**Consultation Response: Kirklees Council Conservation & Design**

**Jagger Lane 17 Kirkheaton conversion of building 2013/93489**

PROPOSED SE ELEVATION

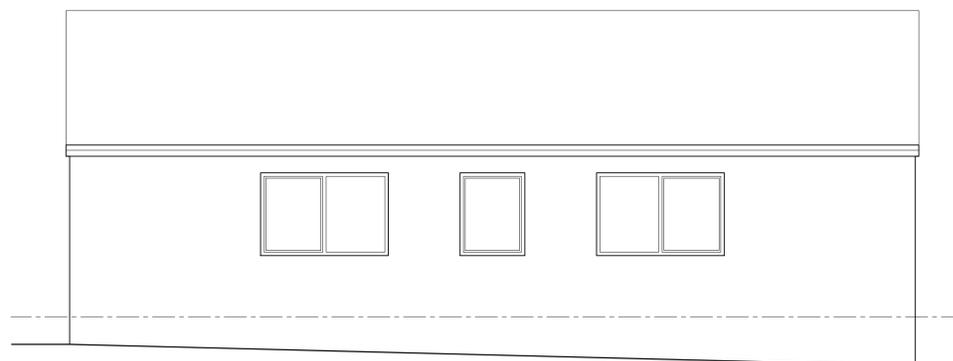
To compensate for the minor loss of grassland a bat box of a type similar to the Schweglar 1 FQ should be erected at the top of the south east facing gable where no windows or doors are to be located. This should be conditioned.

LOCATION PLAN 1:500

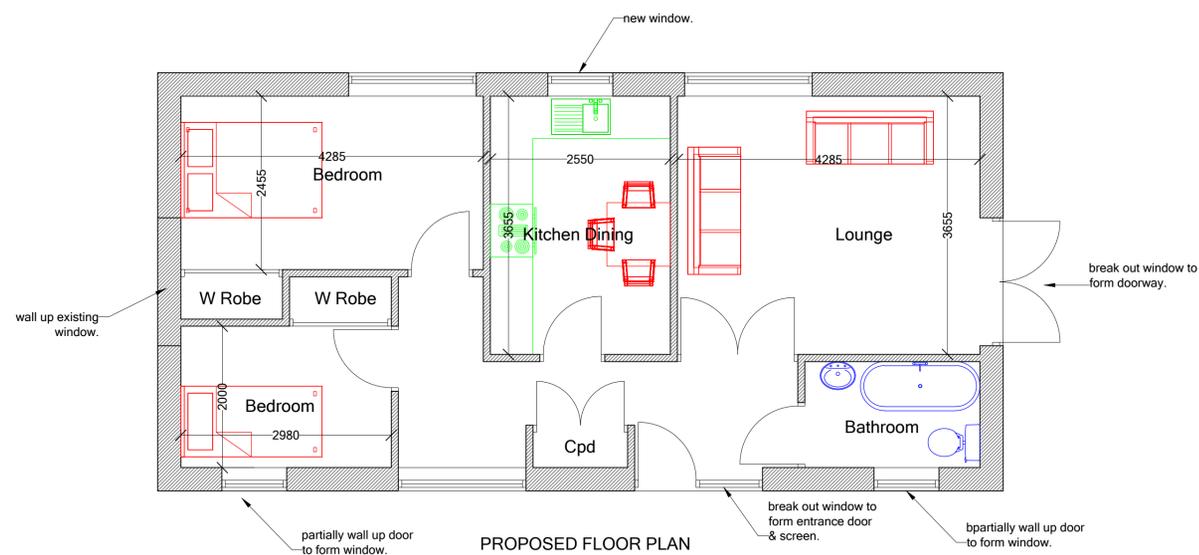
It is not clear of the trees/hedge line is to be affected by the development, in particular the creation of a new access track. Even though the trees do not appear to have any bat roost potential, if it is proposed to remove these trees a compensatory landscape plan based upon the use of native tree and shrub species should be produced predetermination, for approval by the LPA so that this can be conditioned.

In any case, the tree root zones should be protected during and post development, if the trees are to remain.
